Our ref: SSD-70817958

Subject: Request for Additional Information

I refer to the Department of Planning, Housing and Infrastructure's (the Department) letter of 20 May 2025, which advised the Department would be providing comments following the exhibition of the Environmental Impact Statement (EIS) for the proposed DHL Logistics Facility, Badgerys Creek (North) (SSD-70817958).

Lot 01
Warehouse 01
RL 65.00

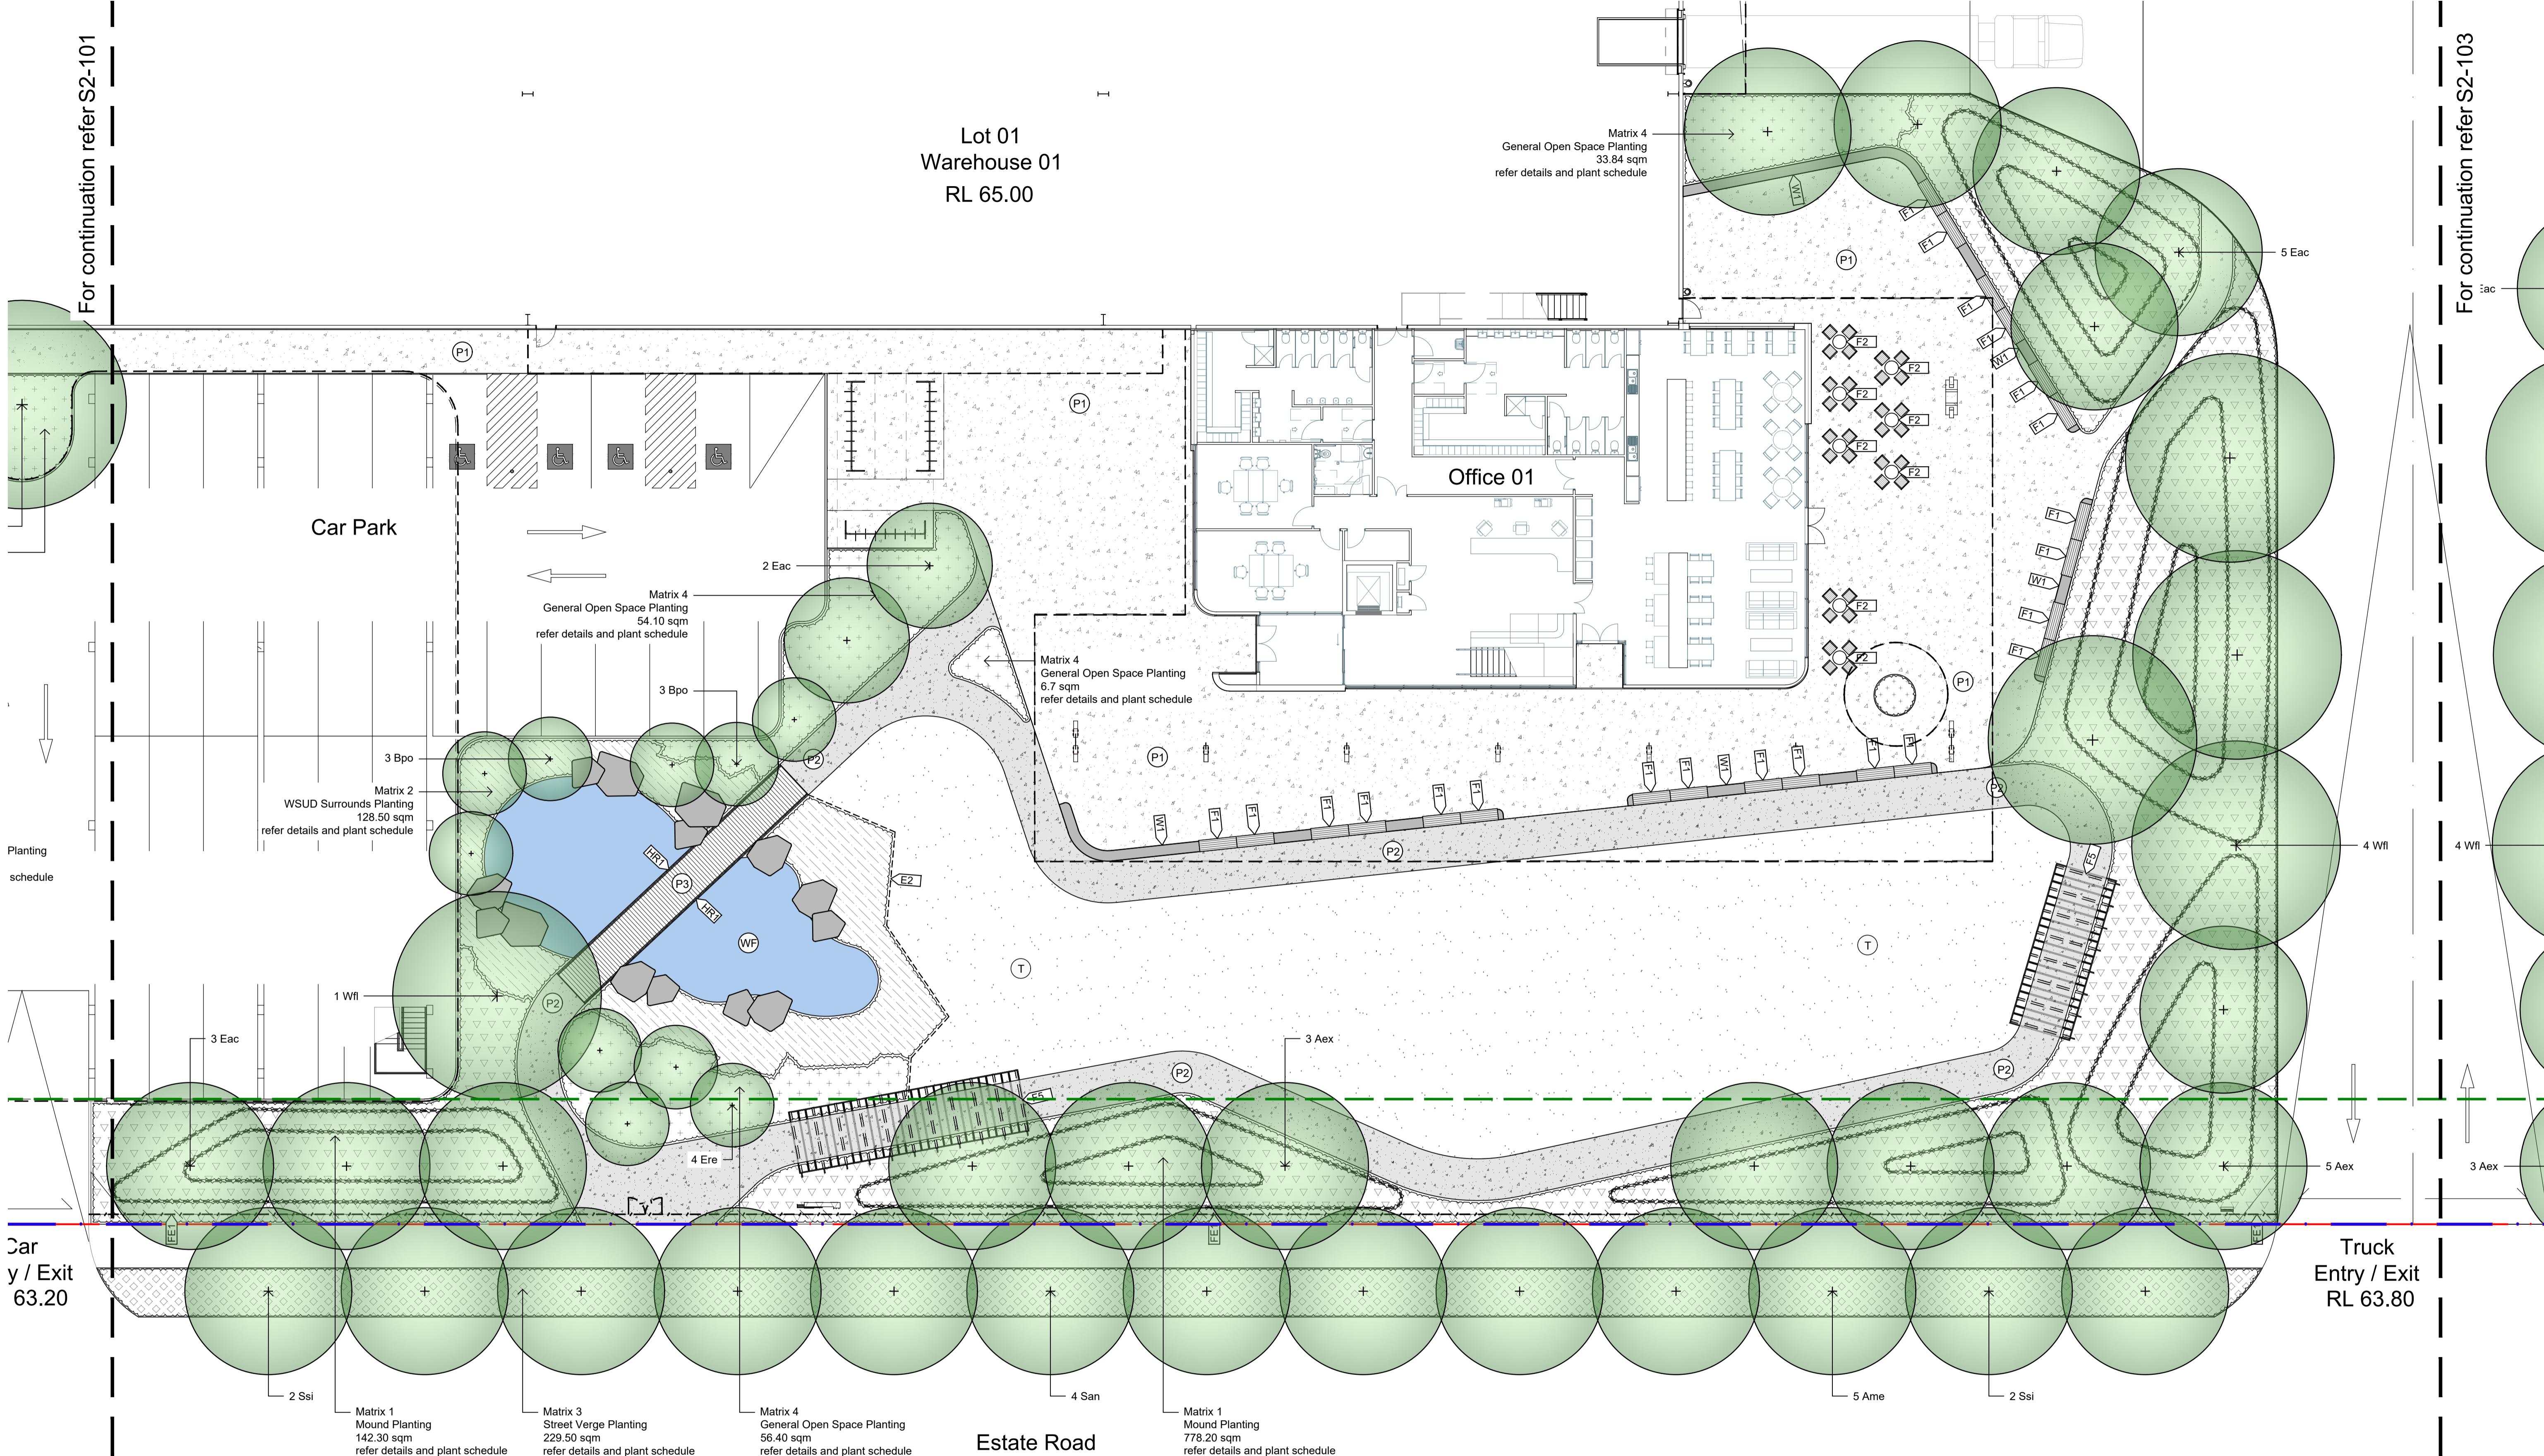
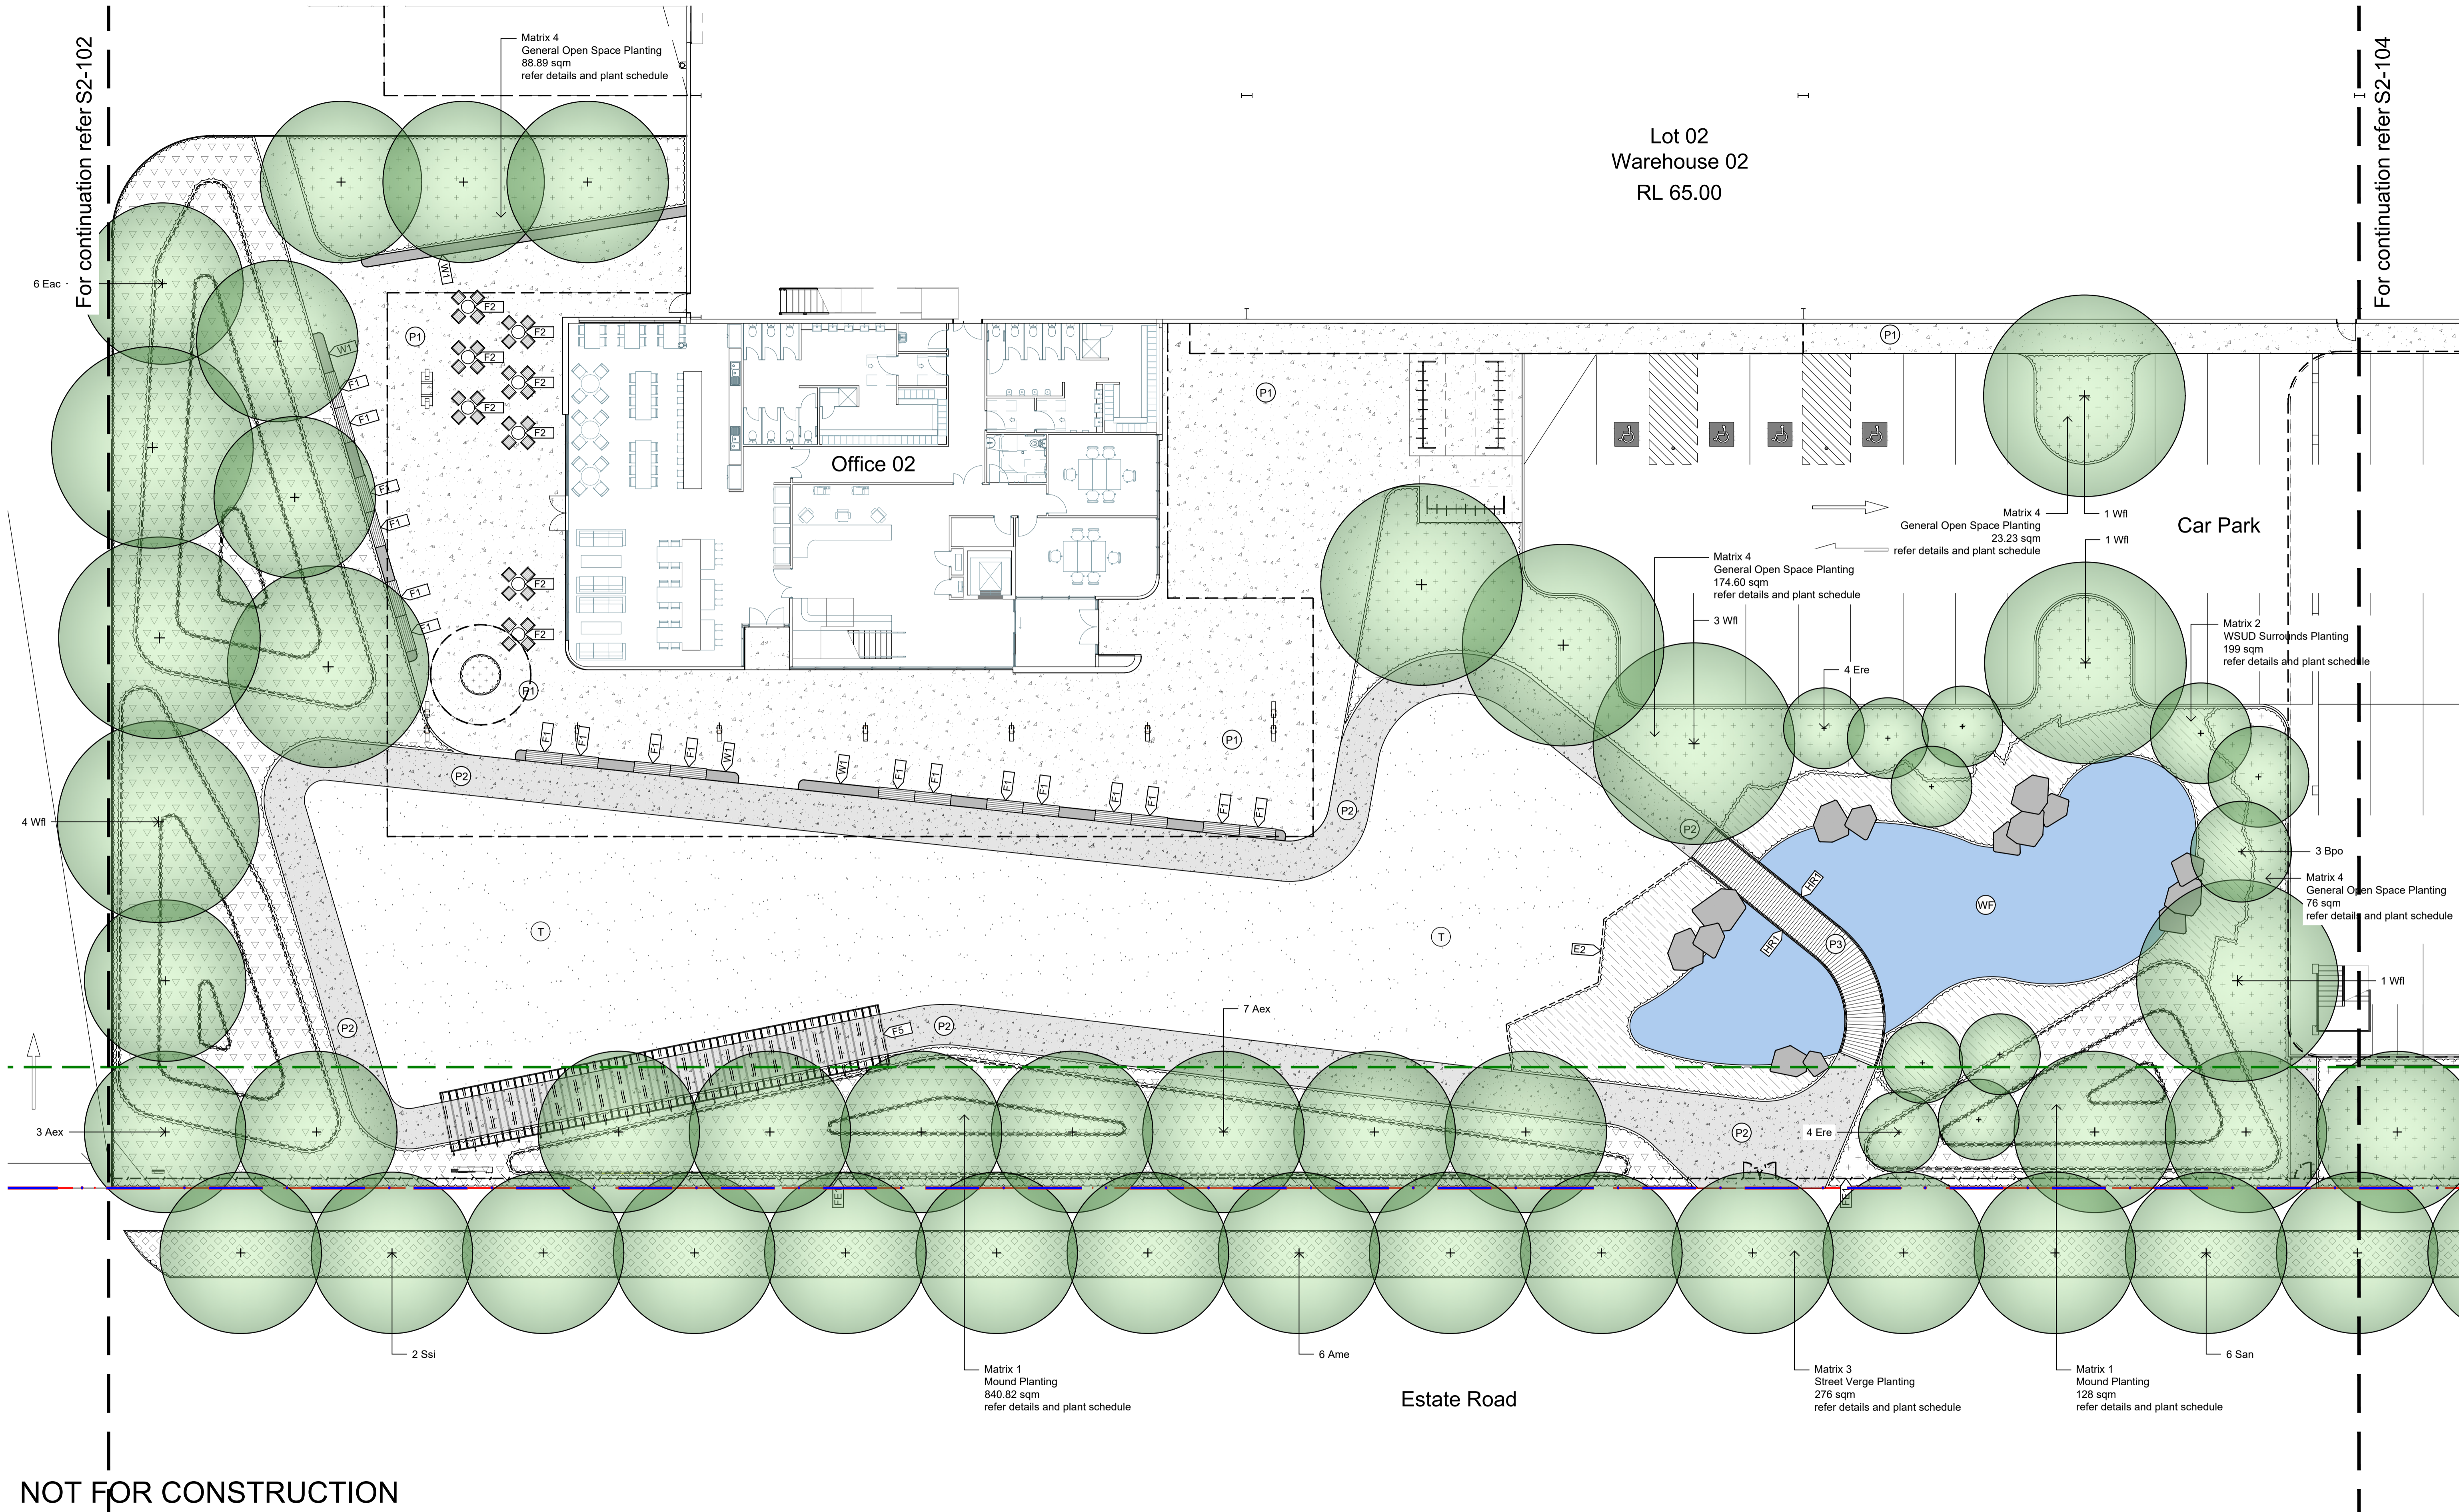
- For the landscaped area to the west of Warehouse 01, please clarify whether this will be publicly accessible and how this area will be maintained.
- Retaining walls are proposed on the northern and eastern boundaries of the site. Confirm that the proposed landscaping and areas of deep soil will be achievable in areas on or adjoining these retaining walls.
